from
**Southern
Water**

Our ref
PLAN-030543

Date
25/11/2019

Proposal: Approval of details reserved by condition imposed under ref Y/5/17/OUT relating to Condition Nos 11 - drainage strategy, 12 - protect existing public sewer, 13 - surface water drainage scheme, 15 - SuDs system and 30 - 10% energy supply from decentralised & renewable sources.
Site: Y/75/19/DOC: - Bridge Cottage, Lidsey Road, Bognor Regis, PO22 9PH.

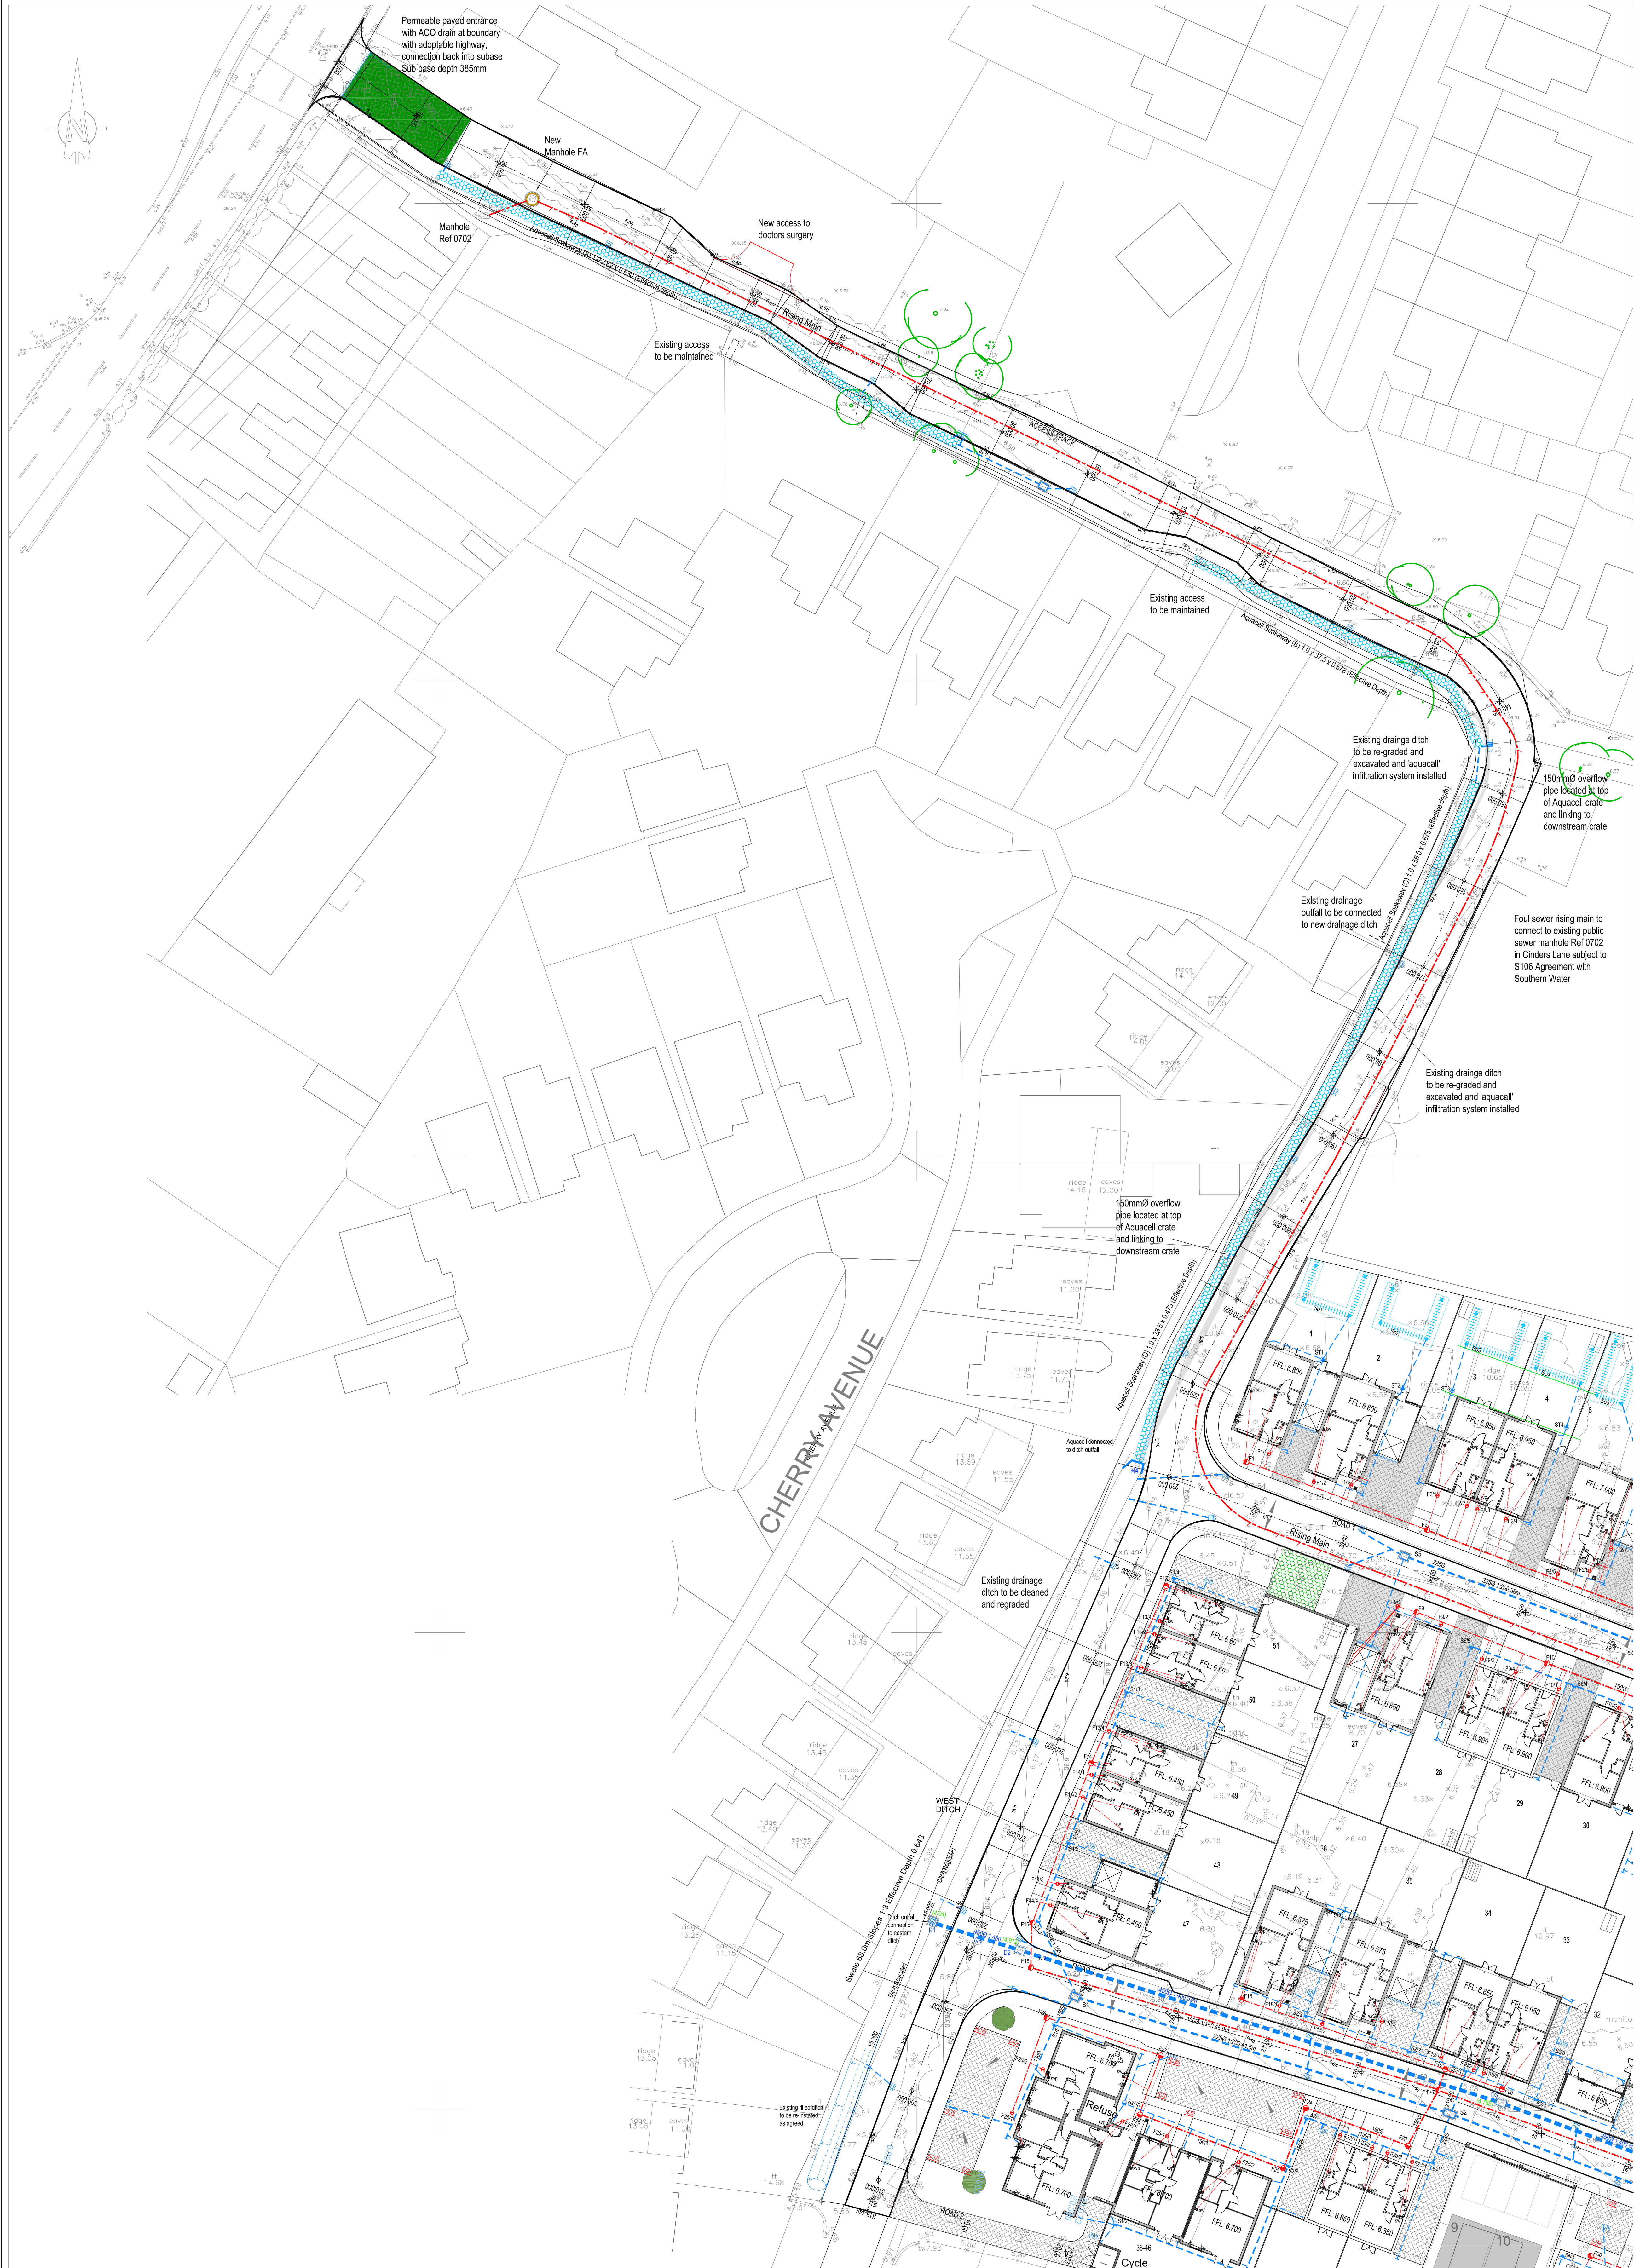
Southern Water cannot recommend discharge of conditions 11, 12, 13 and 15. The submitted drainage layout shows soakaway located within the required minimum distance of 5 metres from public sewer (between manhole 9800 & 0702). A minor realignment will be needed to the soakaway position to create a greater clearance between the soakaway and sewer.

Please note: no soakaways, swales, ponds, watercourses or any other surface water retaining or conveying features should be located within 5 metres of a public sewers.
